CITY OF ALBUQUERQUE

OFFICIAL NOTIFICATION OF DECISION

Project# 1005354
16EPC-40059 Amend Site Development Plan for
Building Permit
16EPC-40060 Amend Site Development Plan for
Subdivision

NM 87103 On November 10, 2016 the Environmental Planning Commission (EPC) voted to APPROVE Project #1005354/16EPC-40059, a Site Development for Building Permit, and 16EPC-40060, a Site Development Plan for Subdivision Amendment, based on the following findings and conditions:

SDP-5.1 V3

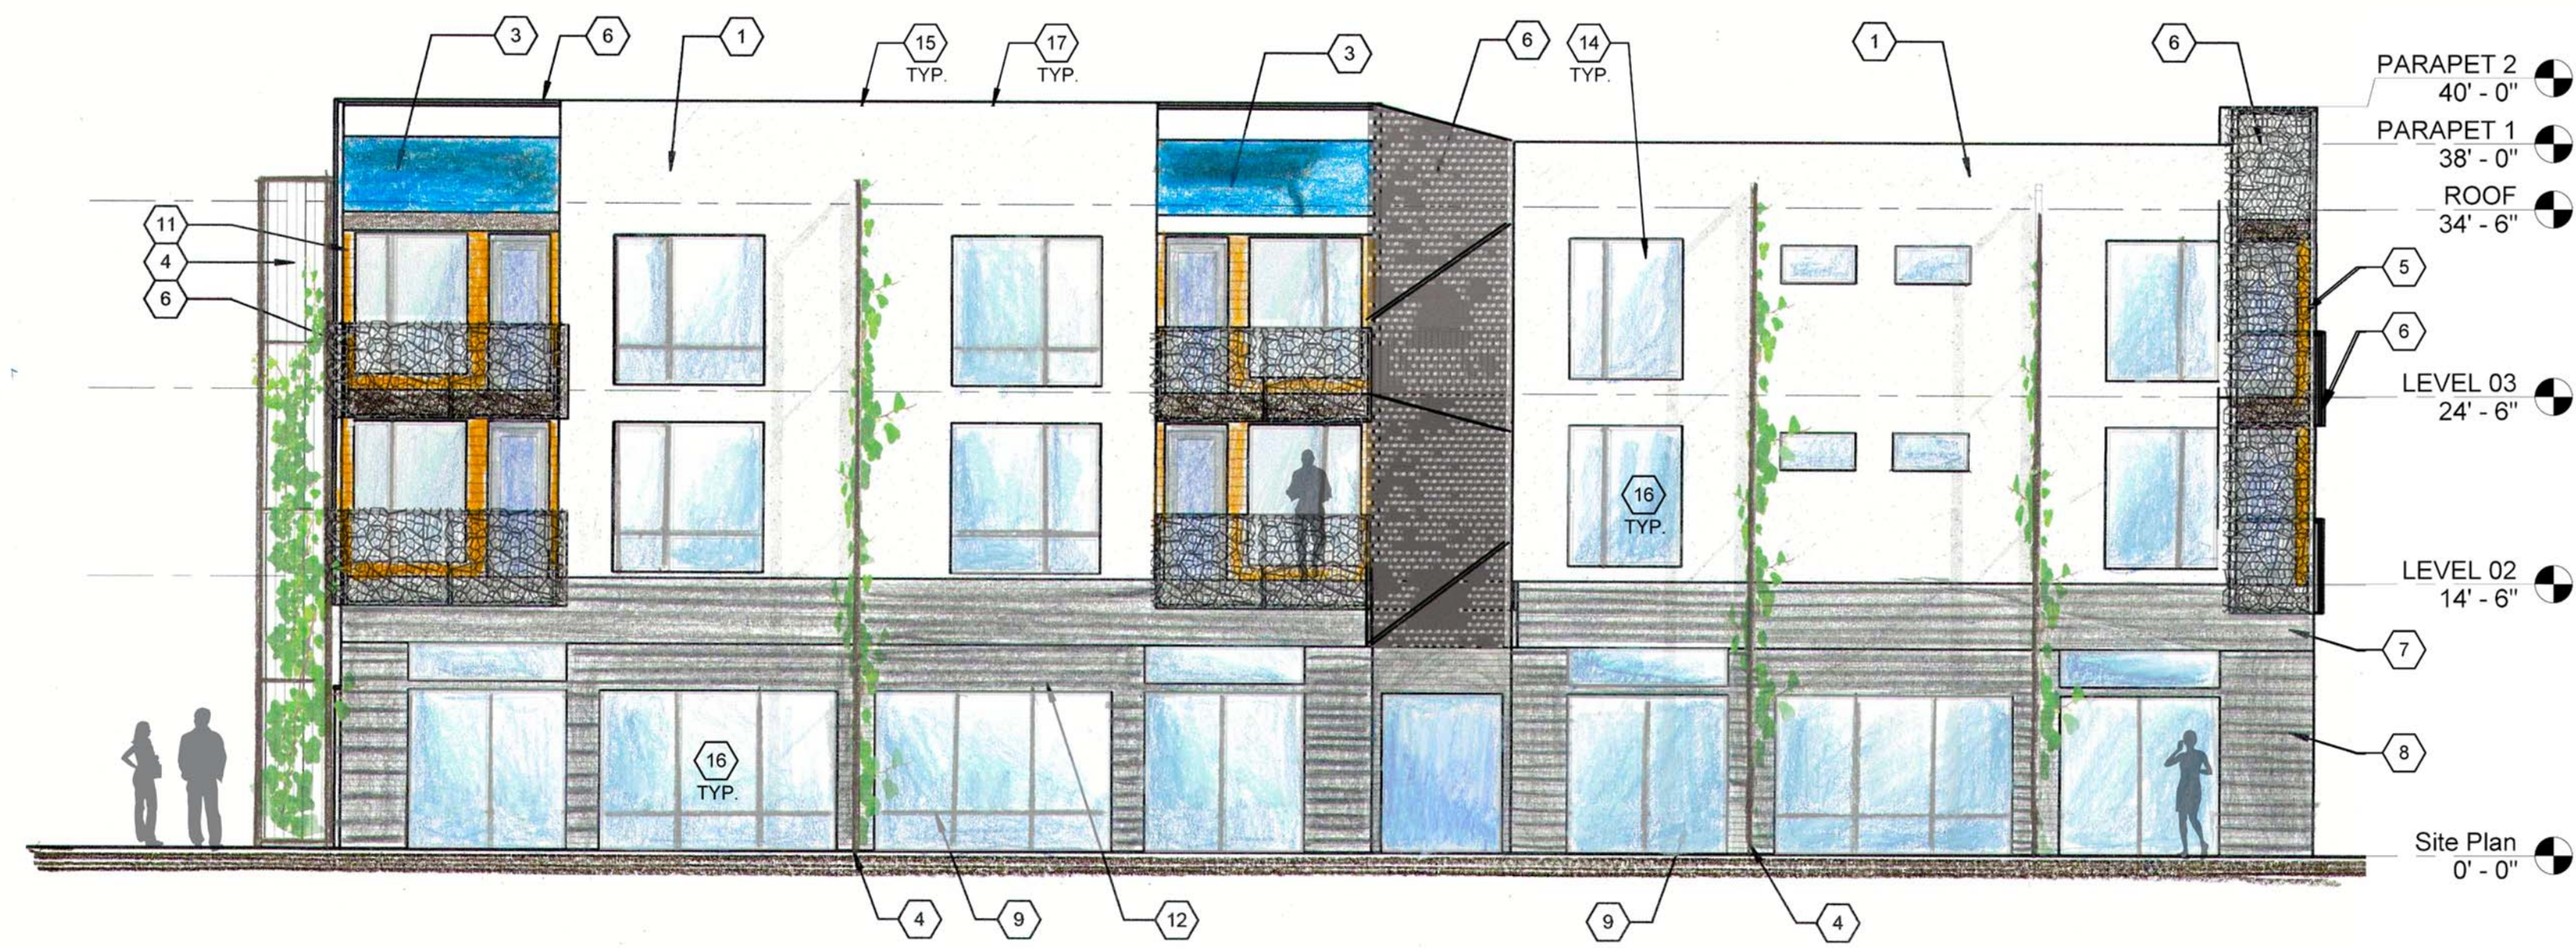
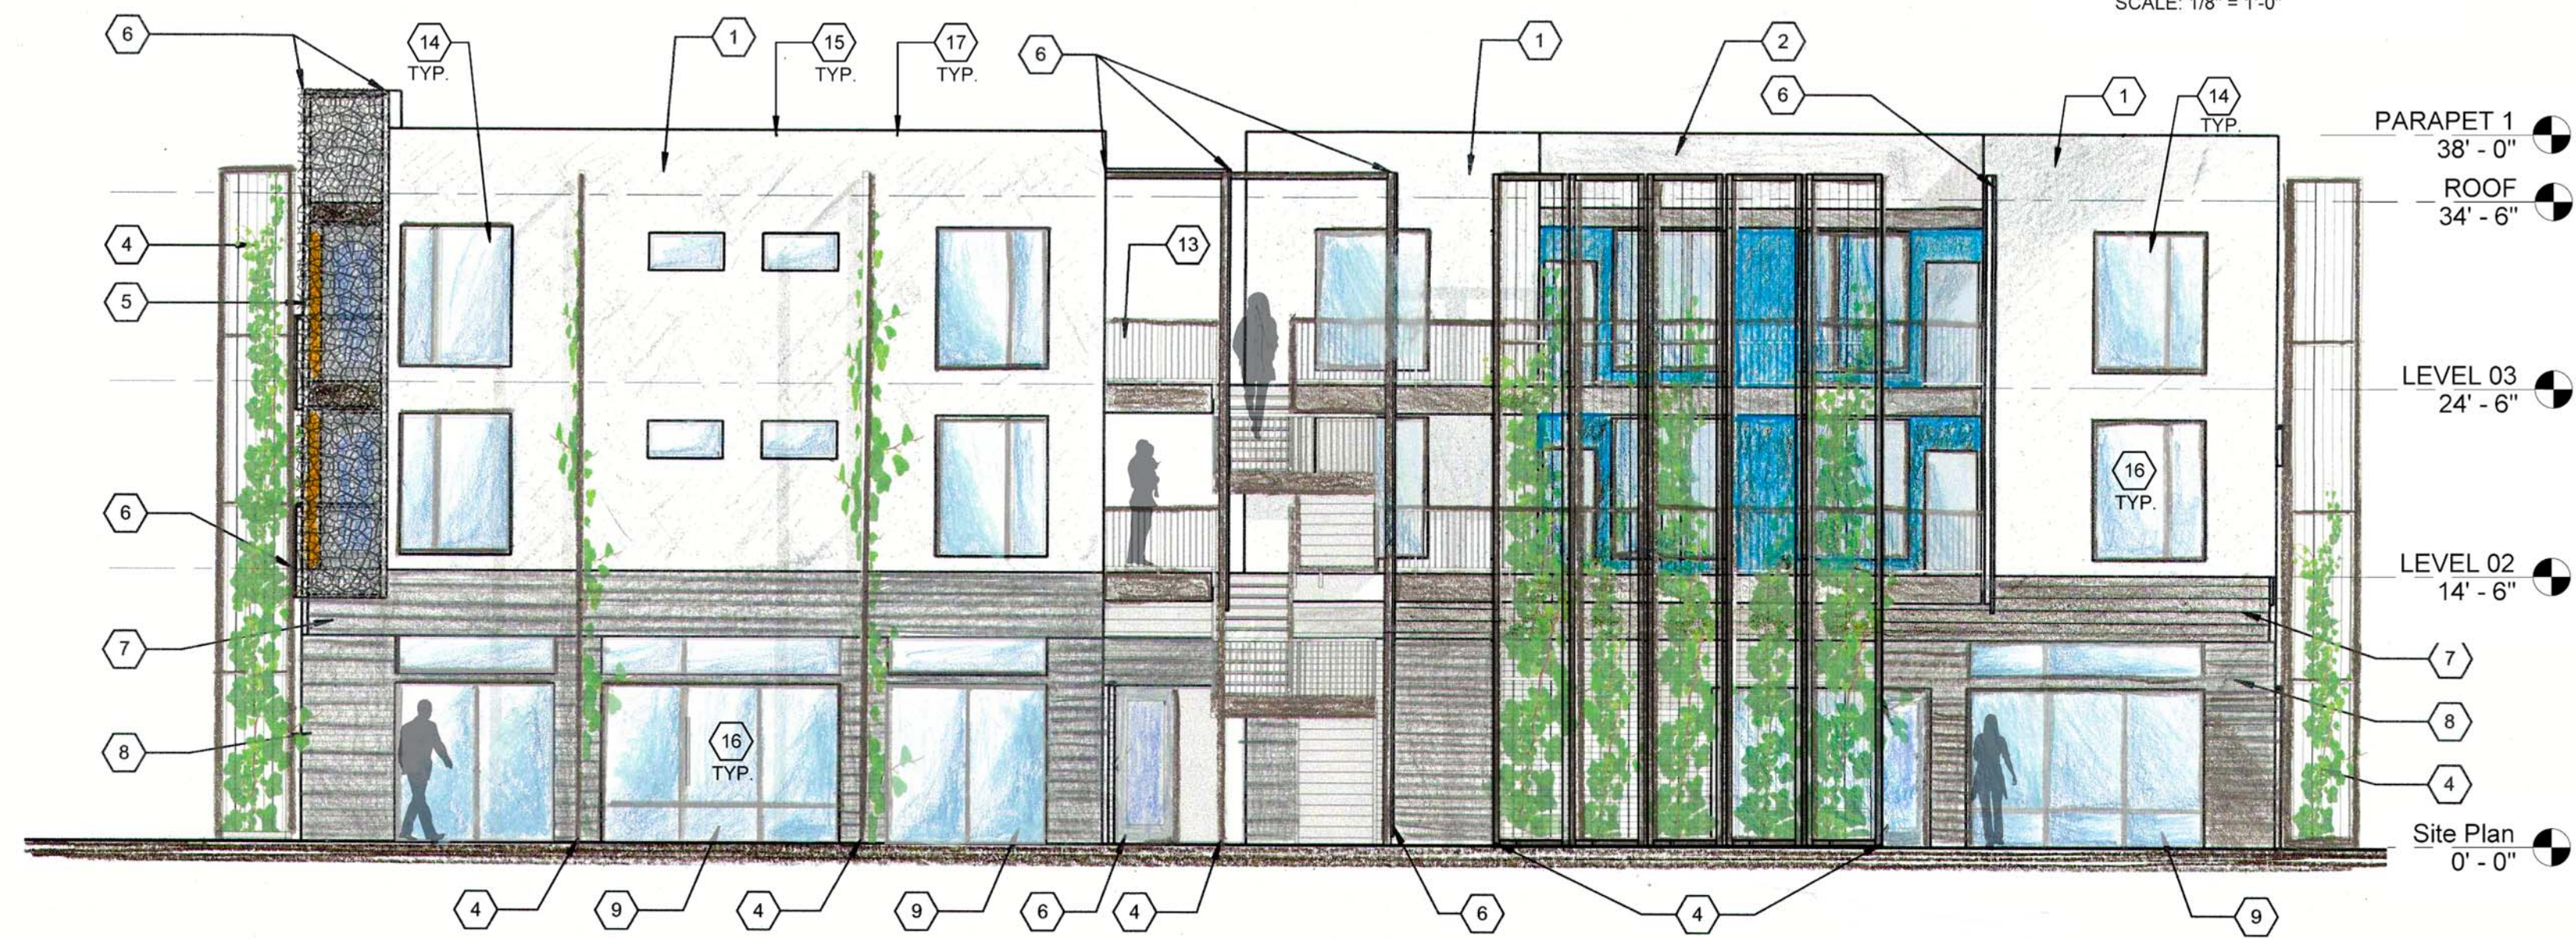
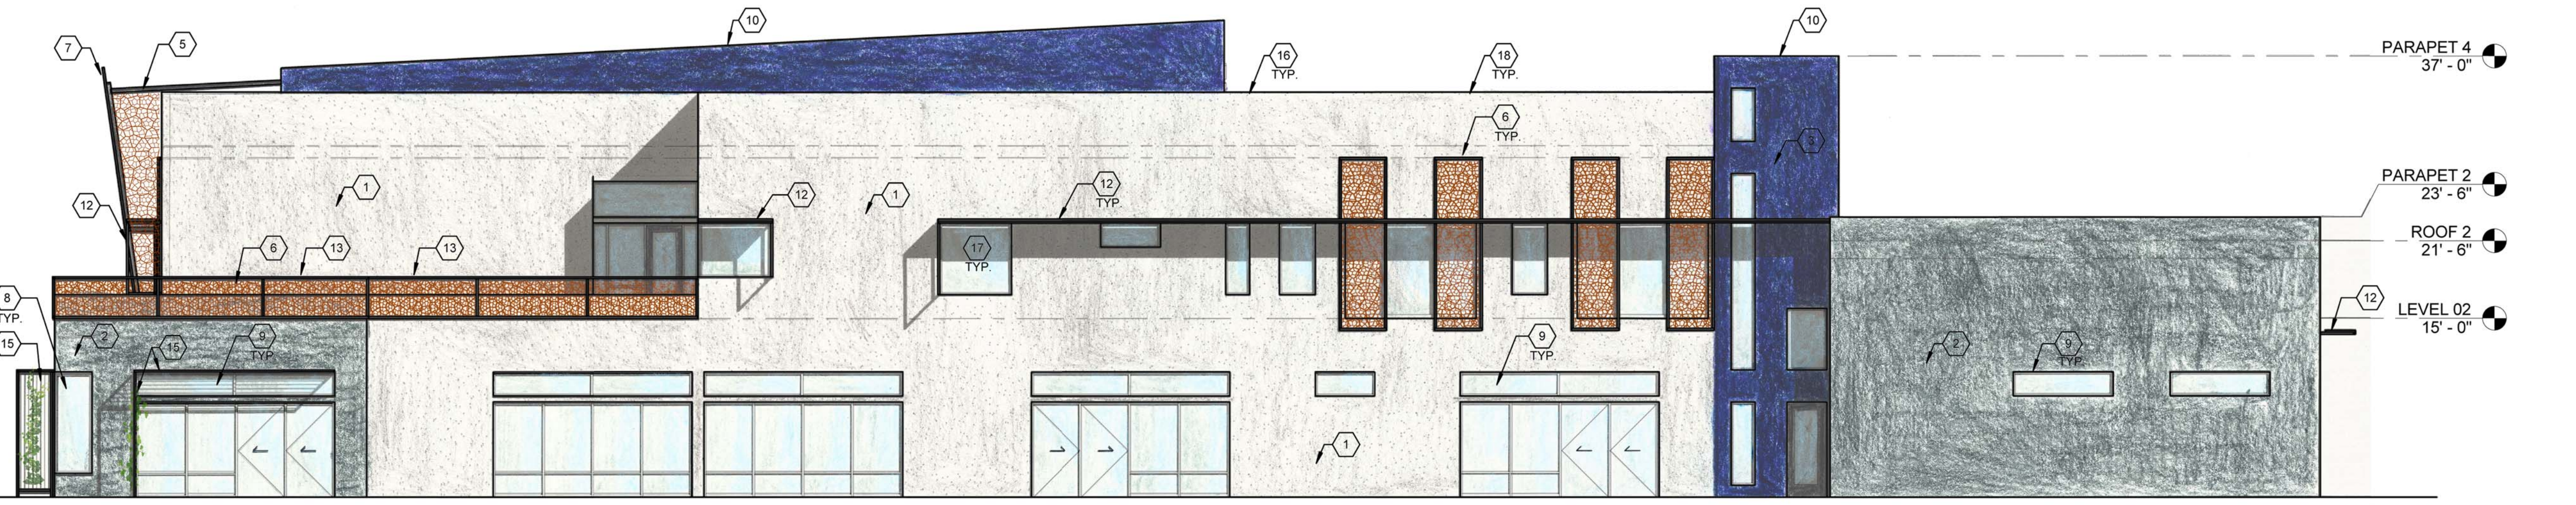
4. SWPSDP General SU-2 Regulations:
 - A. A note shall be added to the elevations to indicate that mechanical and electrical equipment shall be screened from public view (Regulation 4.d).

- B. A note shall be added to the elevations to indicate that reflective glass is prohibited (Regulation 4.f).
5. Parking:
 - A. The parking space counts for the approximately 10-acre site shall be verified and the Parking Table(s) shall be updated correspondingly.
